ADC PARKS & GREENSPACE ARBORICULTURE

PLANNING APPLICATION: R/181/15/PL

ADDRESS: Land to the South of the Tiled barn Station Road East Preston

BRIEF DESCRIPTION: Erection of 2 No. 3 bed dwellings, demolition of existing garage & shed & erection of new car port. Resubmission following R/305/14/PL. This application affects the character & appearance of the Station Road Conservation Area

Drawing title: Tree Constraints Plan

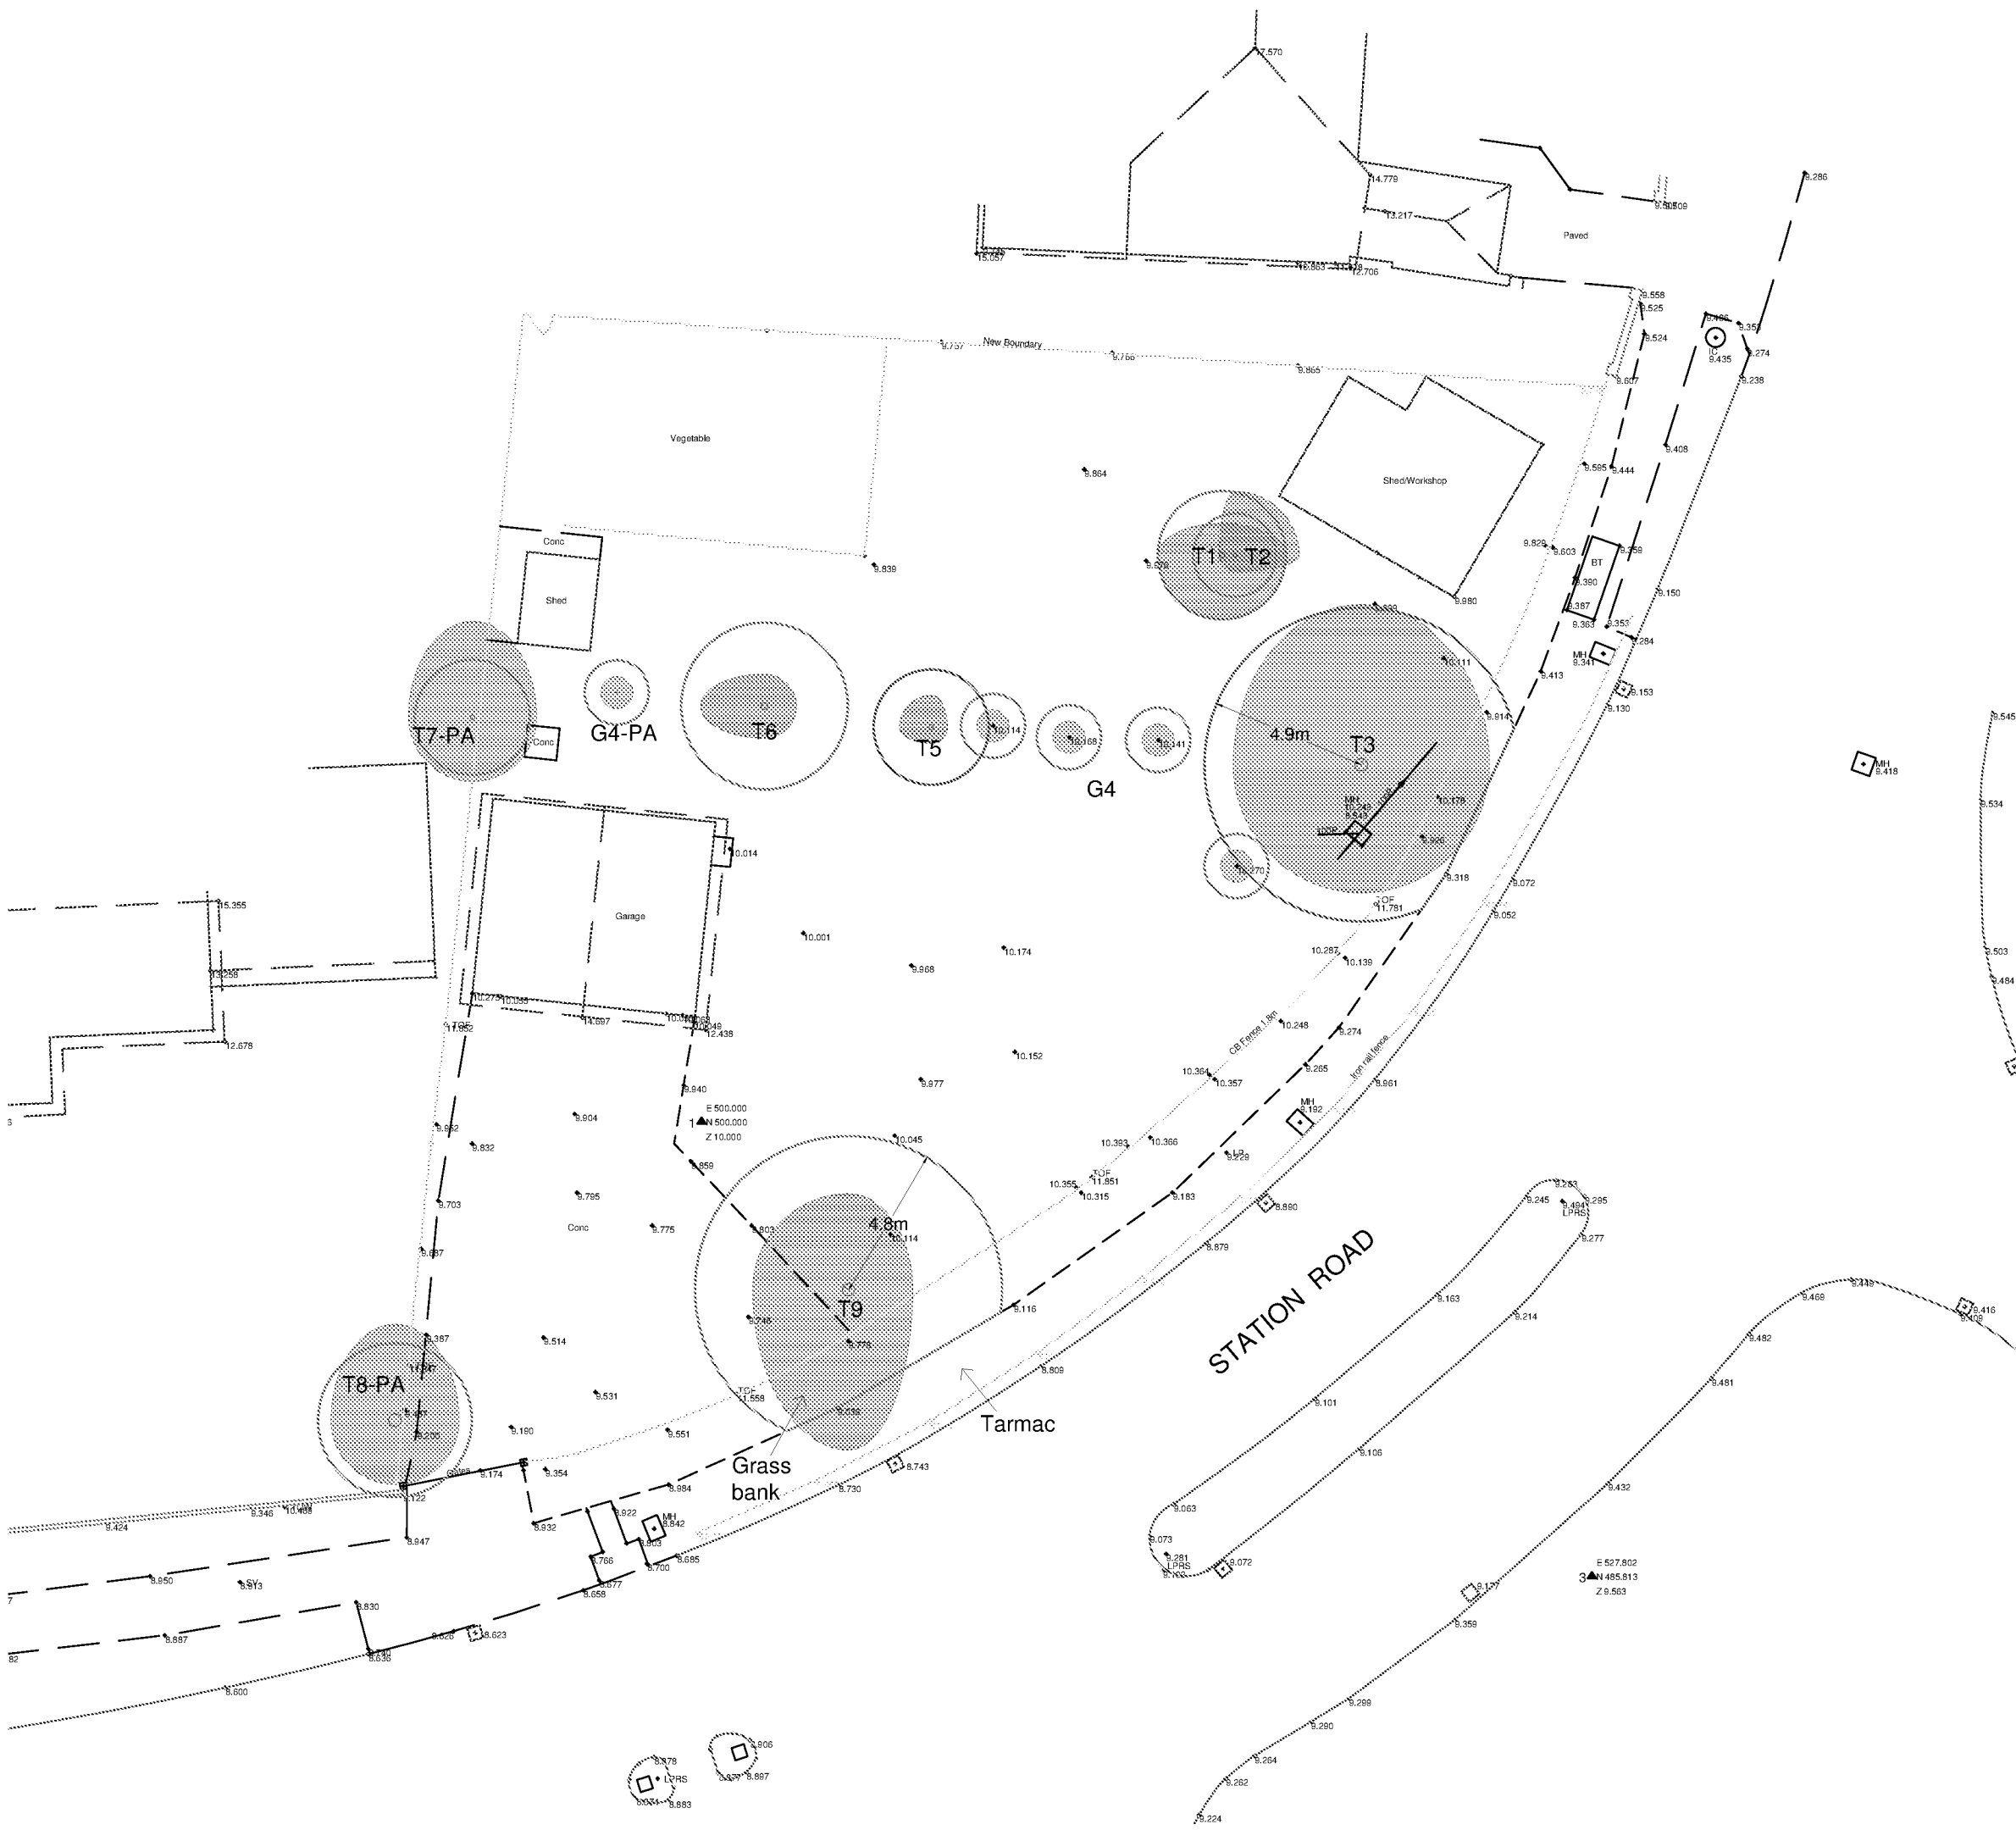
- The submitted application relates to the Erection of 2 No. 3 bed dwellings, demolition of existing garage & shed & erection of new car port.
- The application has outlined the desire to fell **T1, T2, G4, T5, T6** and **T9**. I would object to the felling of **T9**, as I believe it has the attributes to warrant a TPO order. (Please see attached TEMPO forms). I would have no objection to the felling of **T1, T2, G4, T5, and T6**.
- I would have no objections to the hard surfacing encroaching **T3** by 16.3% and **T7** by 34.1%, as the applicant has stated the surfacing material must be a geotextile membrane.
- I would also have no objection to the proposed crown lift of 2 meters, and the lateral reduction of no more than 1 meters to **T3**, as it is unlikely to have any lasting negative impact to **T3**.

- I would object to the felling of **T9**, as it has the attributes to warrant a TPO order. **I would however have no objection to the remainder of the application.**

- If **T9** is retained under TPO, alterations would have to be made to the submitted application to ensure damage is not inflicted. This would include suitable RPA/tree protection for the duration of the construction process. Also alterations are likely to have be made membranes/surfacing to the west of **T9**, where the proposed parking and turning area is due to be placed, as this area is likely to overlap with the RPA of **T9**.
